Please ask for: Ms Iqraa Malik
Email: iqraa.malik@terraquest.co.uk
Telephone: 01212341390
Our Ref: M/87/20/HH
Your Ref:
Date: 18th November 2020

Application for Planning Permission for Works or Extension to a Dwelling

Development: Rear extension and alterations to existing dwelling
Location: 25 West Close Middleton-On-Sea PO22 7RP

DRAWING - PROPOSED
Plans
Elevations & Section
Block Plan
Location Plan

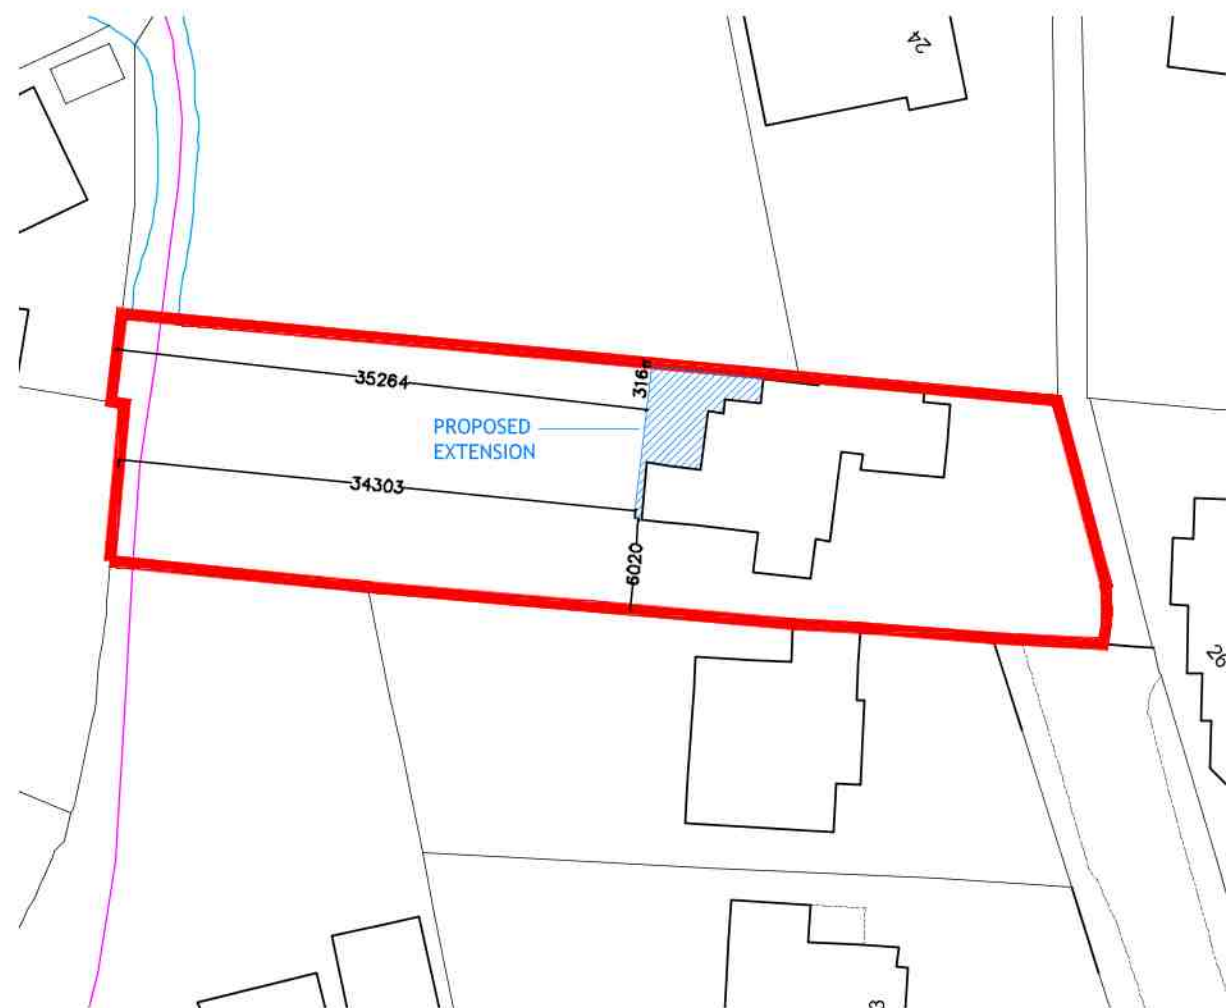
Dimensions: You are required to include dimensions on the block plan from the proposed extension to all site boundaries
